PROJECT NO. PR-2021-002309

DESCRIPTION: Reponse Letter, Plat, Revised infrastructure lists, Access exhibit

**RE: LA MIRADA SUBDIVISION
PRELIMINARY PLAT AND SITE PLAN
DRB PROJECT NUMBER: 2021-002309**

Per the correspondence via email of Ms. Jeanne Wolfenbarger, PE, City of Albuquerque Development Review Board Transportation Comments, dated September 29, 2021, please find the following responses addressing the comments listed below:

ENGINEER'S SEAL	THE WYMONT ALBUQUERQUE, NM	DRAWN BY pm
	VEHICLE AND PEDESTRIAN CONNECTIVITY EXHIBIT	DATE 8-16-21
RONALD R. BOHANNAN P.E. #7868	TIERRA WEST, LLC 5571 MIDWAY PARK PL NE ALBUQUERQUE, NEW MEXICO 87109 (505) 858-3100 www.tierrawestllc.com	DRAWING
		SHEET # 1
		JOB # 2021008

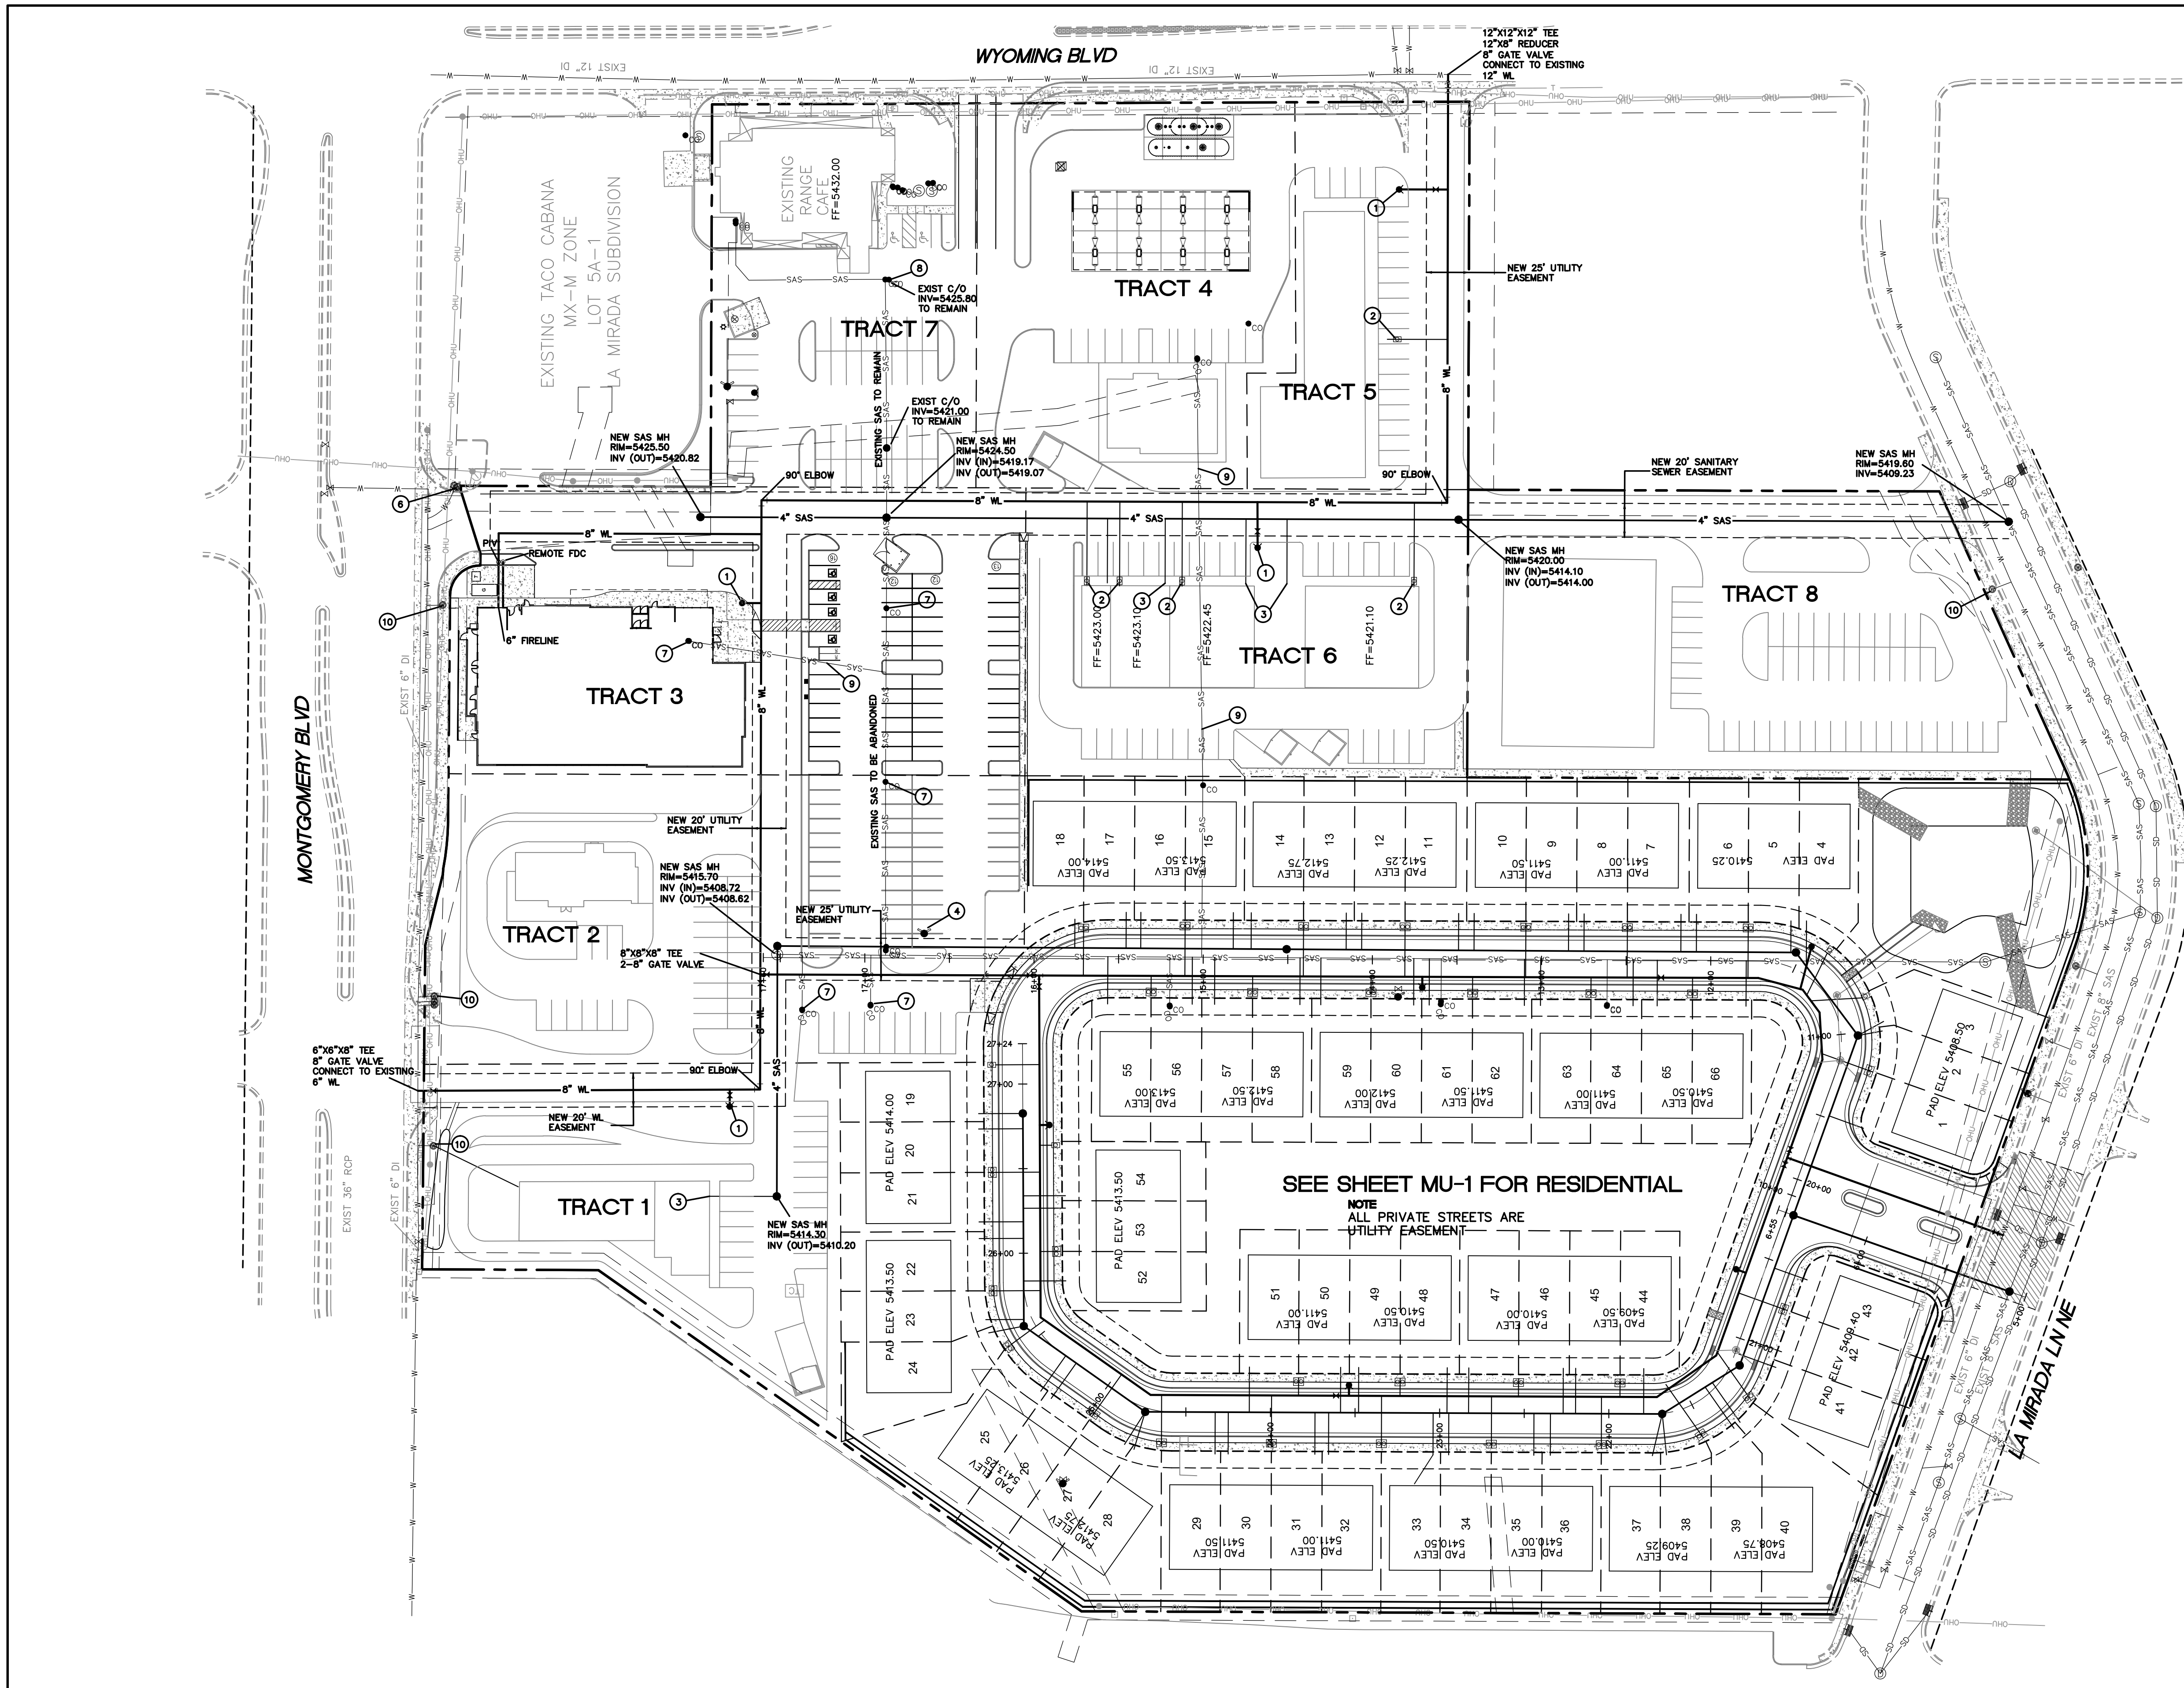
1. The eastern north/south sanitary sewer within the non-residential tracts is labeled as 4-inch. From the proposed design, this would need to be an 8-inch public sewer main.
This sanitary sewer line is shown as an 8" line.
2. Please demonstrate sufficient public easement for the public sewer main to tract 1.
A 20' sanitary sewer easement is shown on the plat.
